**Re: Submission in respect of translucent sheeting to be used on
buildings located at Lot 201, 202, 204 & 206, DP 1244593 335-
337 Burley Rd Horsley Park**

Travers Bushfire & Ecology has been requested to undertake a review of bushfire development consent conditions for an industrial development being constructed on the above land – see Figure 1 below.

Issue

Building 201 and Building 202 are nearing construction completion and the translucent roof sheeting proposed for a portion of the roof, on each building, is contrary to AS3959 (2018).

**Figure 3** – roof profile for B201 (HLG Architects)

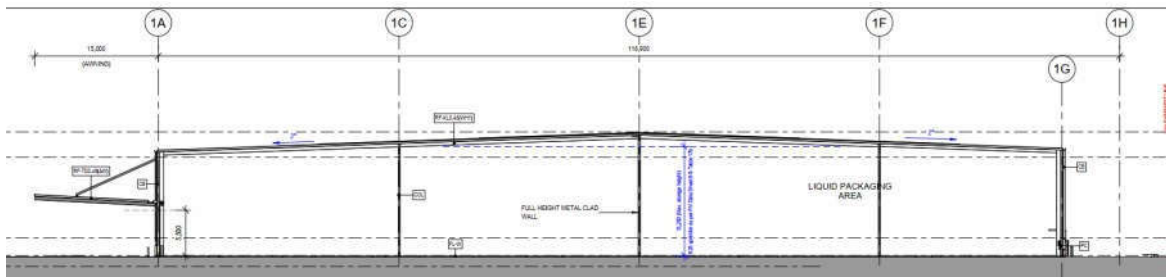
Importantly, the roof shape for each building provides a very low pitch which enables the roof to be a ‘self shedding design’ that aids in denying the build-up of leaf material/s which could, when sufficiently aggregated, be ignited by airborne embers. See roof shape below in Figure 3.
